Our Ref: AW/208/17/HH
Your Ref:

Development Single storey front extension as annex for elderly relative
Location 31 Queens Fields West Aldwick

Existing Elevations

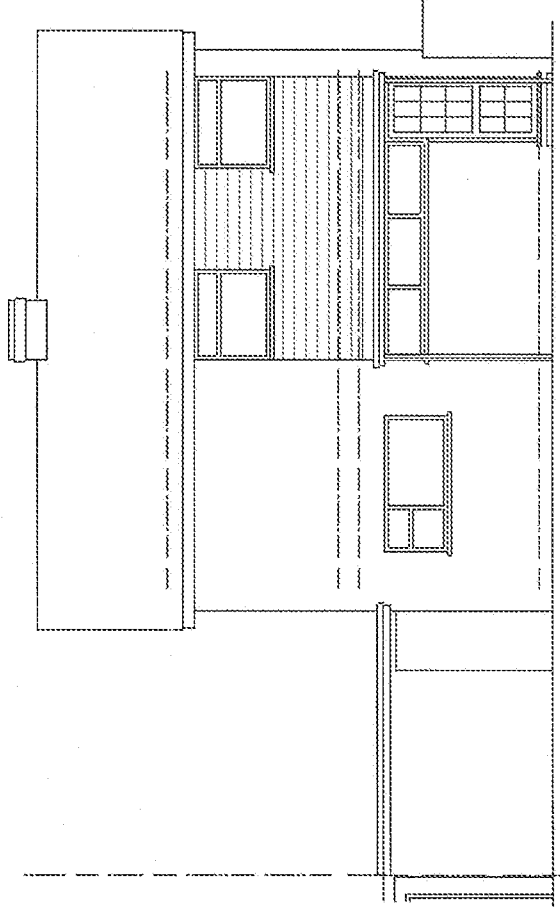
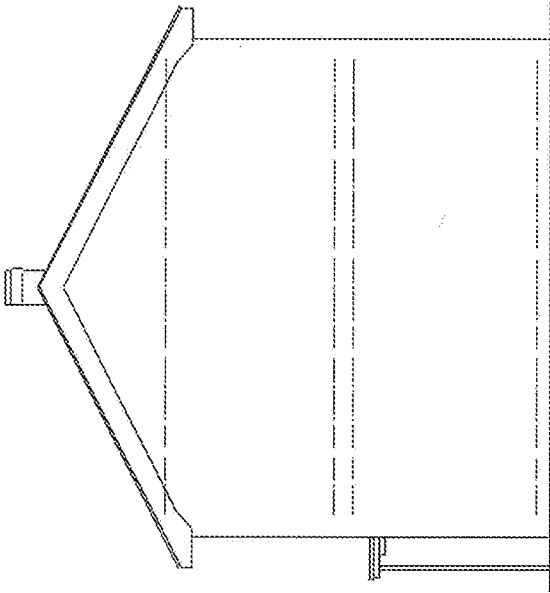
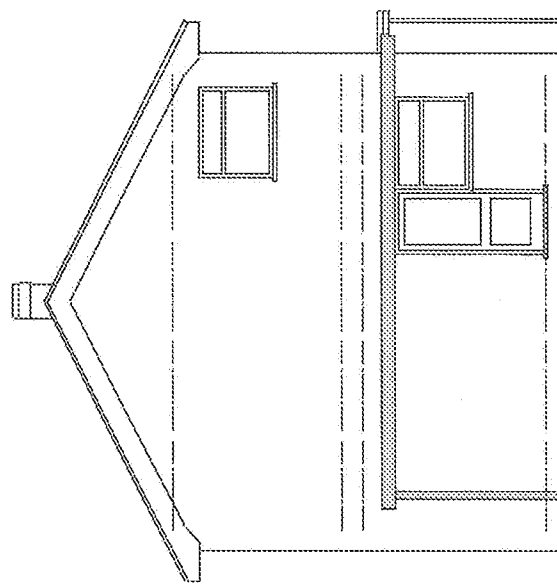
The existing and proposed floor plans and elevations do not seem to accord. Please include the structure attached to the East of the house onto the existing and proposed floor plans and elevations.

Block Plan 1:500

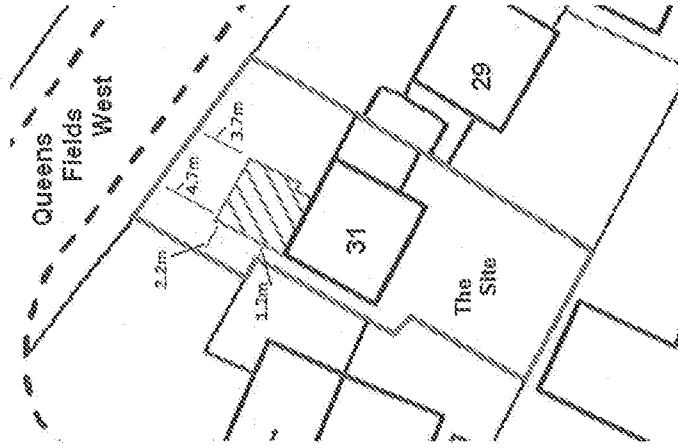
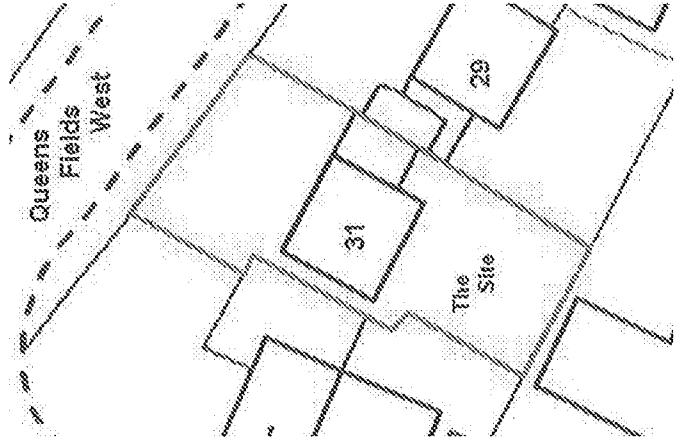
Block Plan Amend

Please submit 1 electronic or 3 paper copies of a block/site plan at a scale of 1:500 or 1:200. Further details of what must be included on the plan can be found in the National Validation Requirements. Please provide measurements from the proposal to the site boundaries.
